MEMORANDUM

FROM: Charlene Durham, Engineering **CCES Responses**
719-520-7951
Jeff Rice, Engineering
719-520-7877

SUBJECT: SF-22-041 – Retreat at TimberRidge Filing No. 3
Fifth Submittal

**SITE MAP/ GRADING, EROSION CONTROL PLAN**

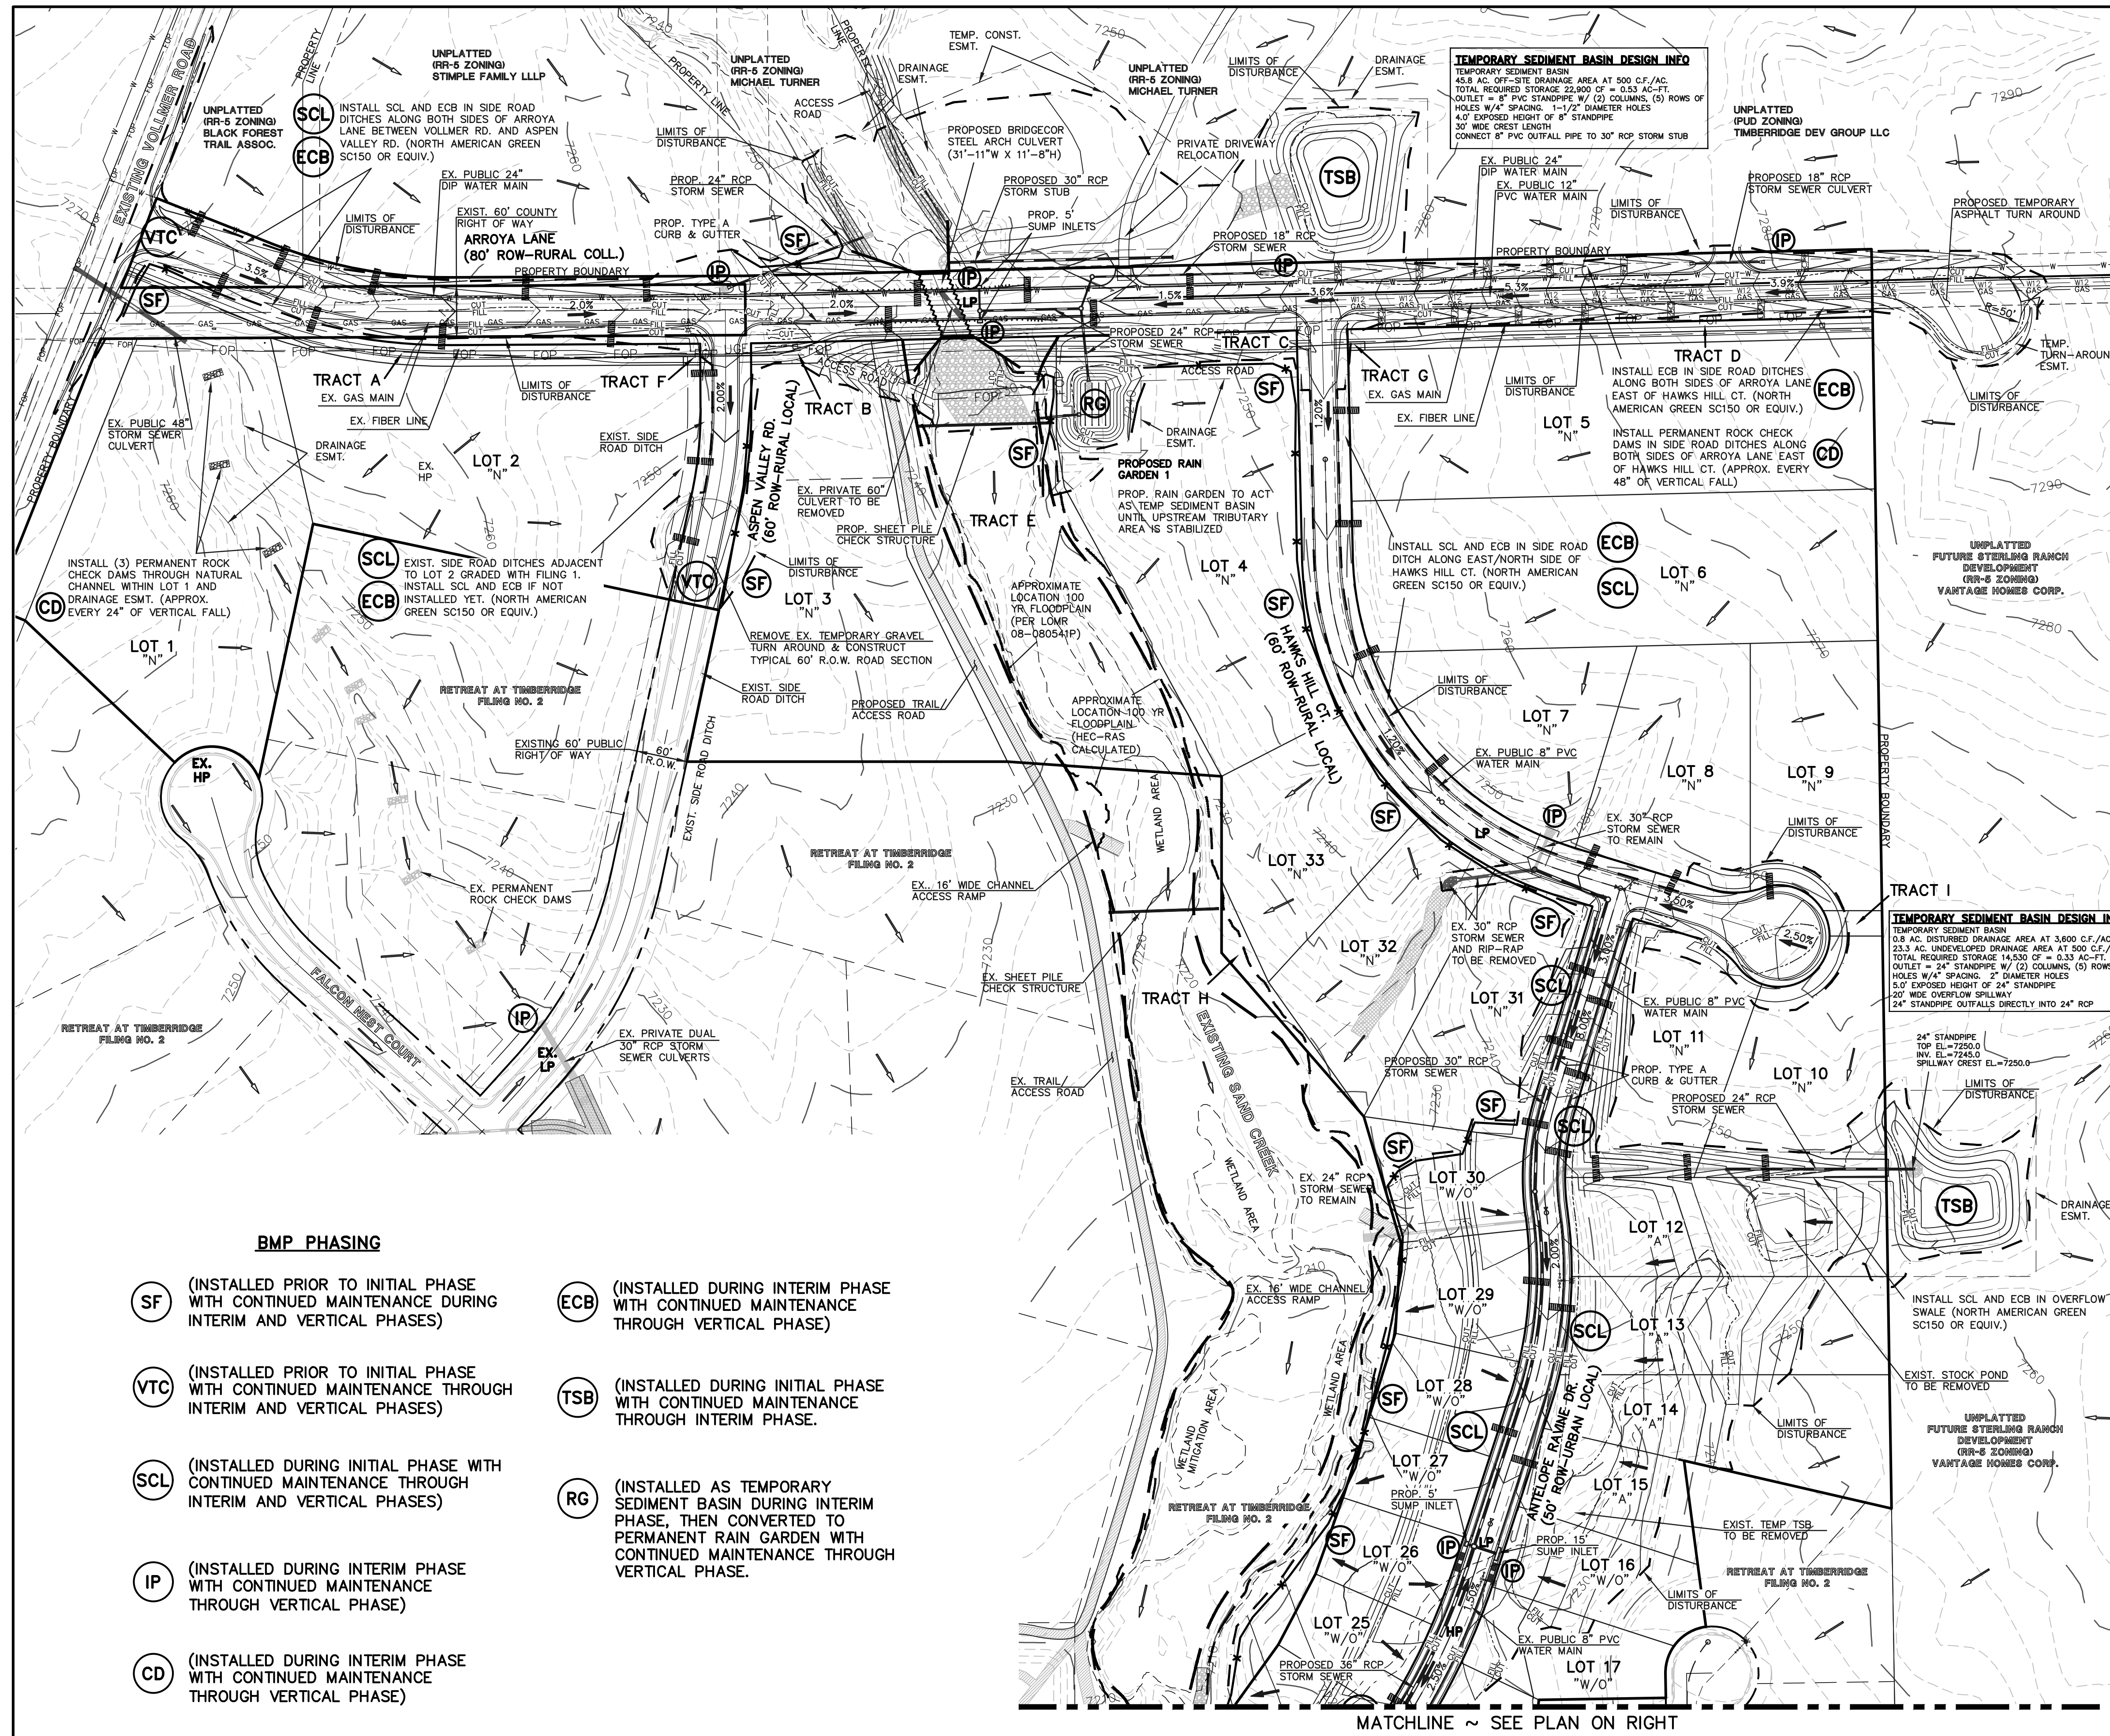
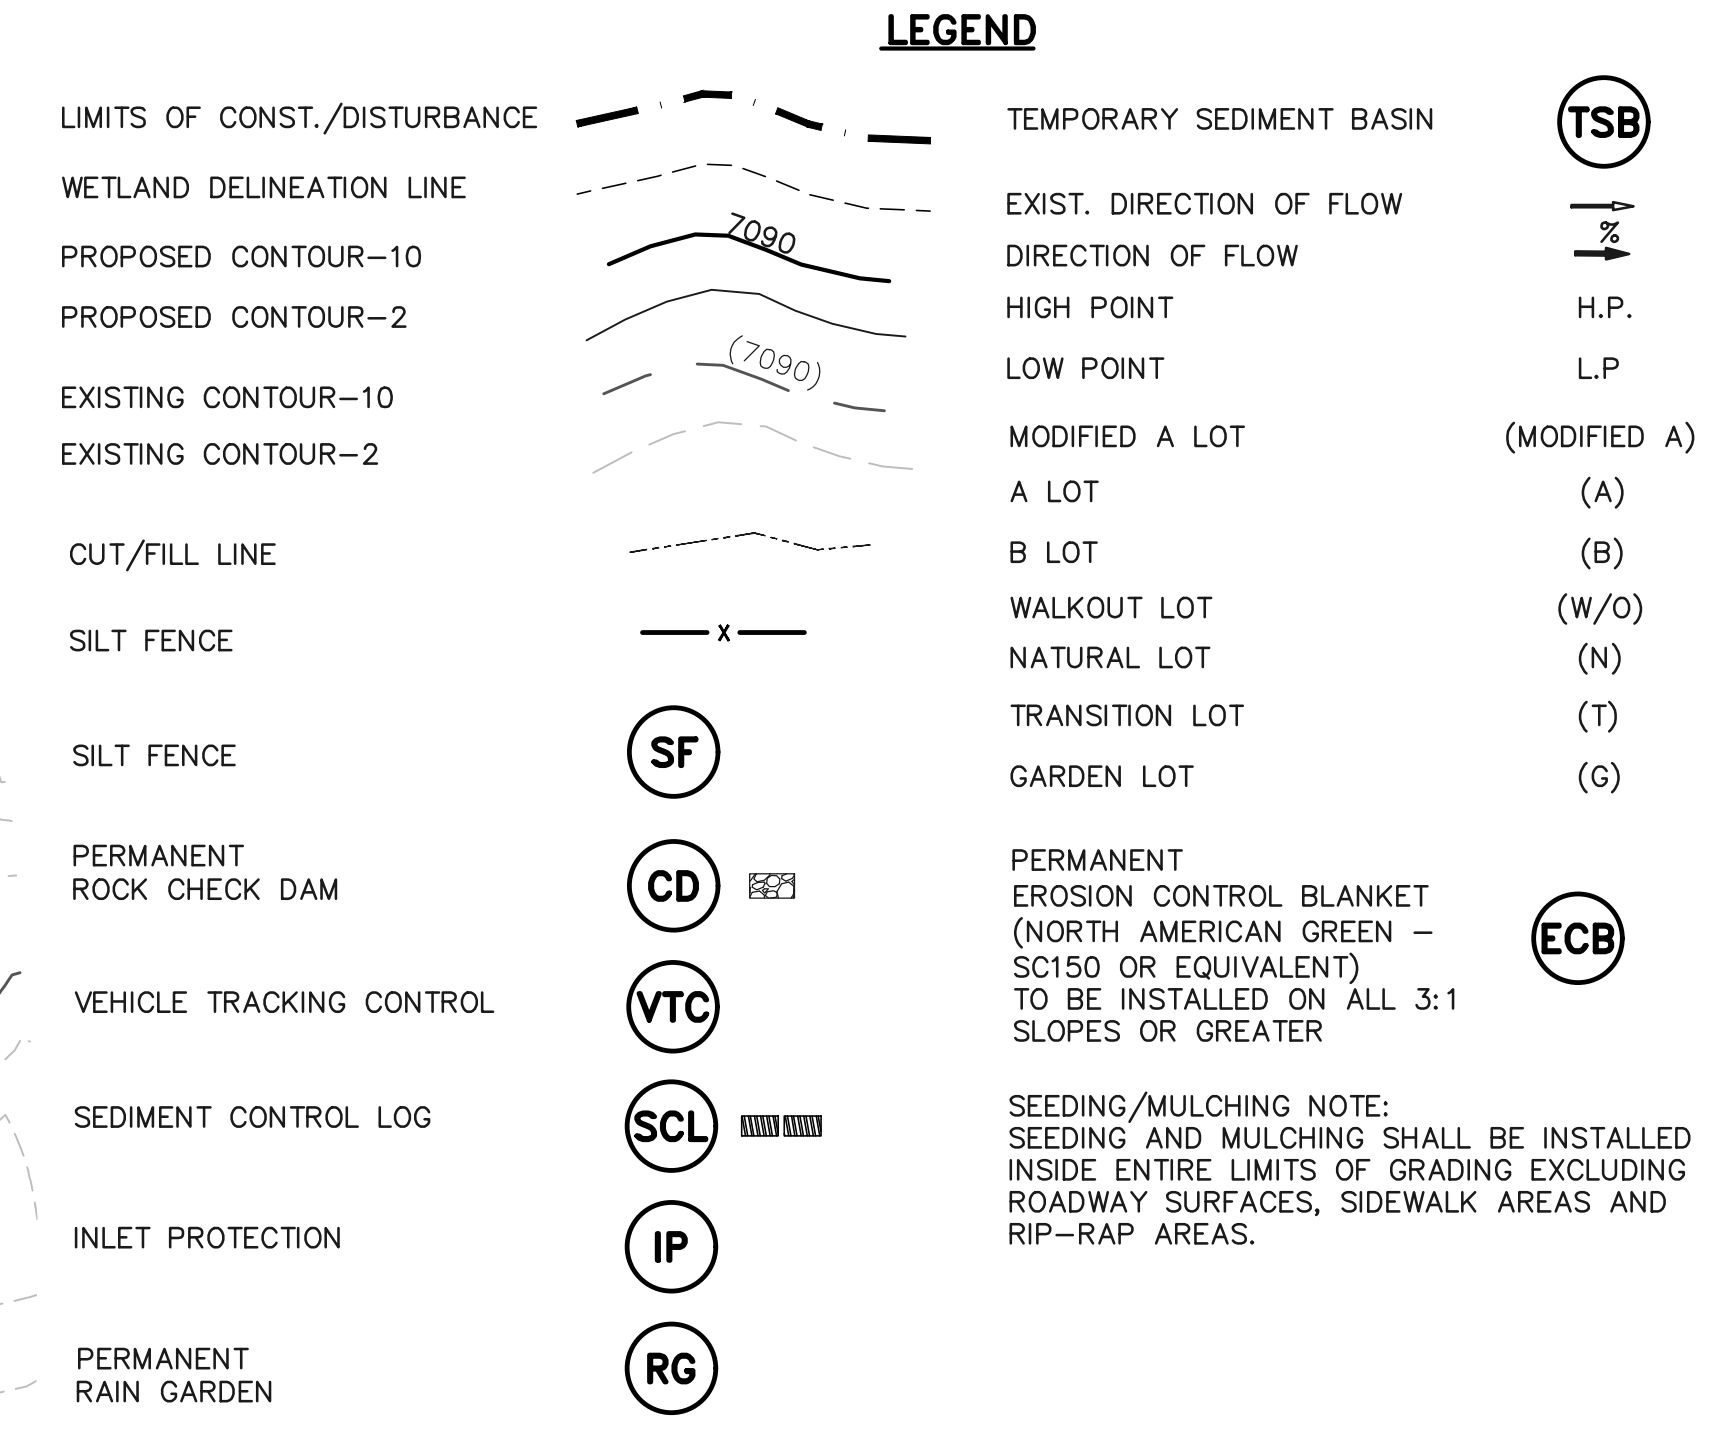
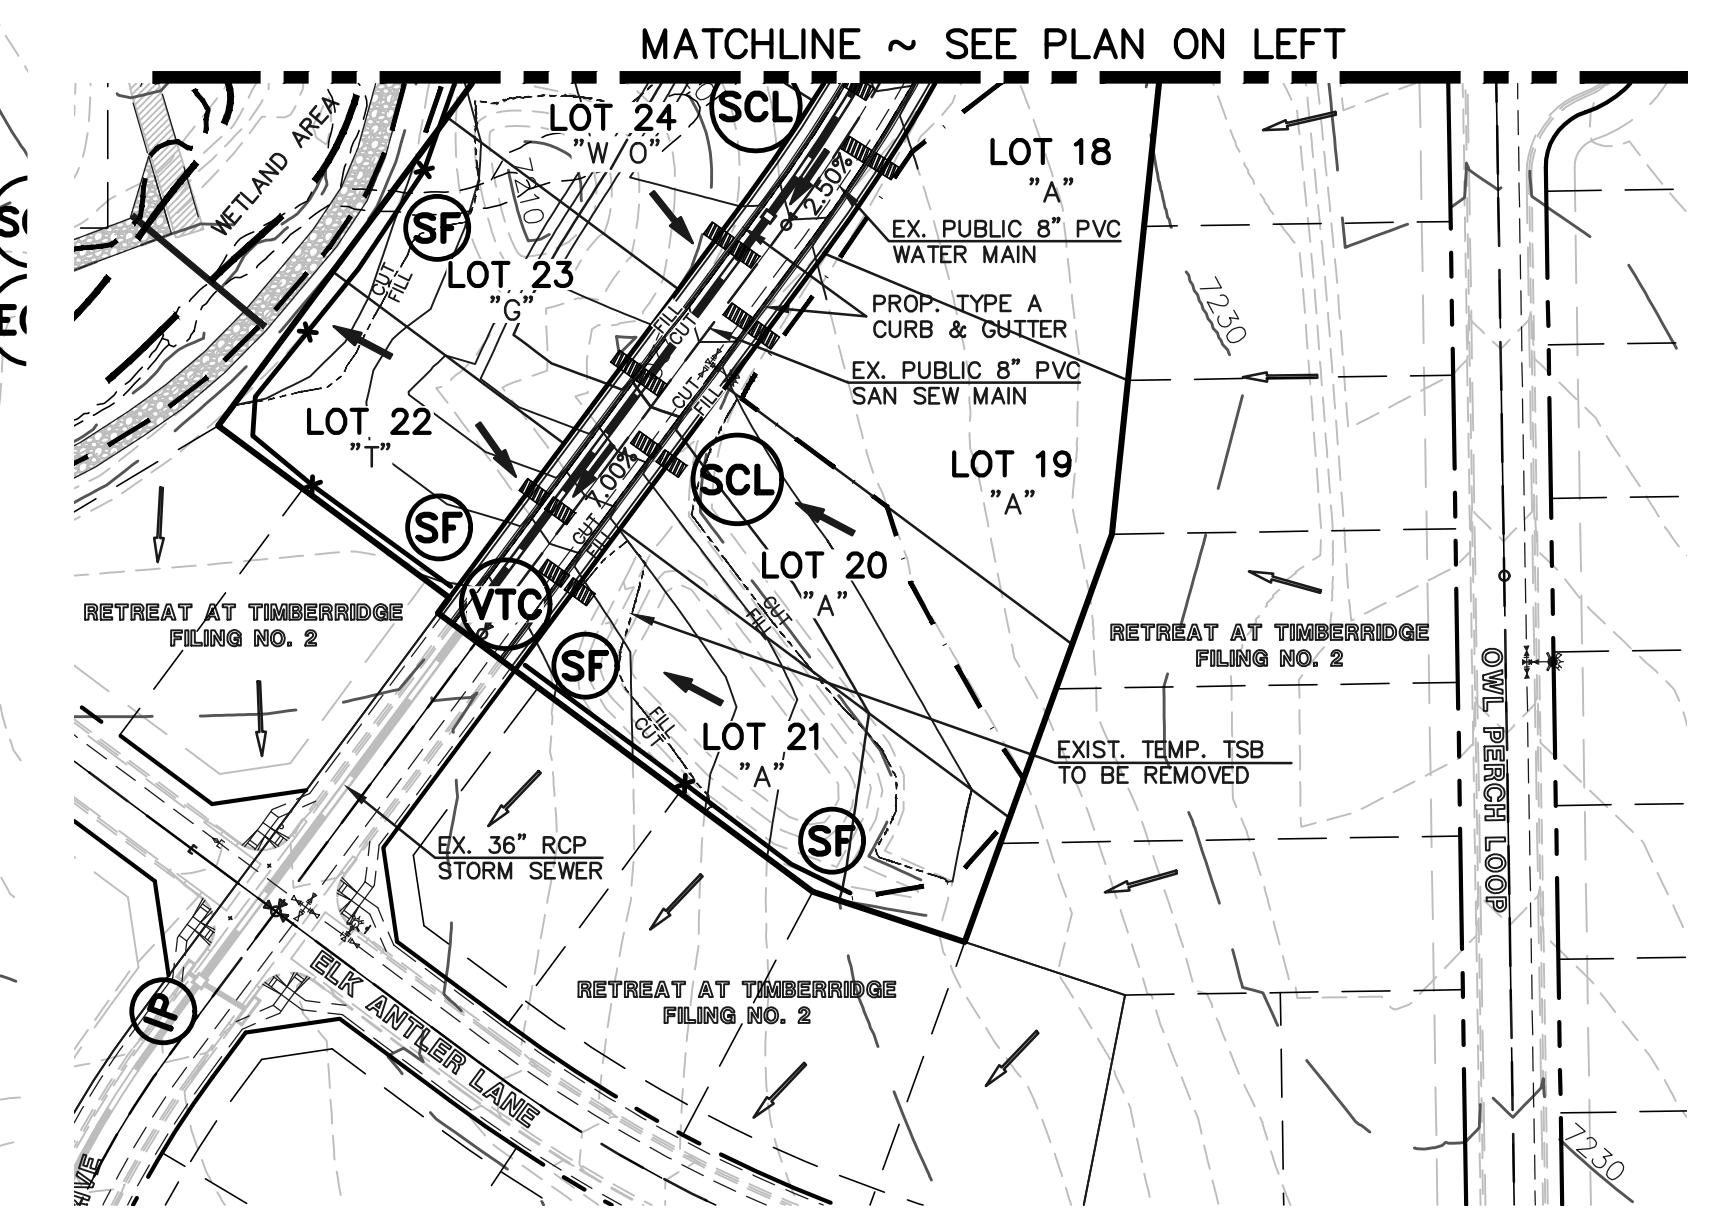
1. **See updated CD/GEC redlines. See revised GEC sheet**
2. Provide the County CD signature block on the separate utility plans. Show the underdrain stub locations on the utility service locations details and note and/or show the underdrain system outfall(s) on the CDs. (Revise plat notes and provide a sump pump

outlet plan for lots on urban roads if not proposed.) ***Partially resolved; if the underdrain outfall is offsite, coordinate with Staff on a note to be added.***

Unresolved. The proposed underdrain in Hawks Hill cul-de-sac ties into the existing underdrain already constructed south down Antelope Ravine Dr. This sewer line and underdrain were constructed with Filing No. 1. This facility is now labeled on the service plans.
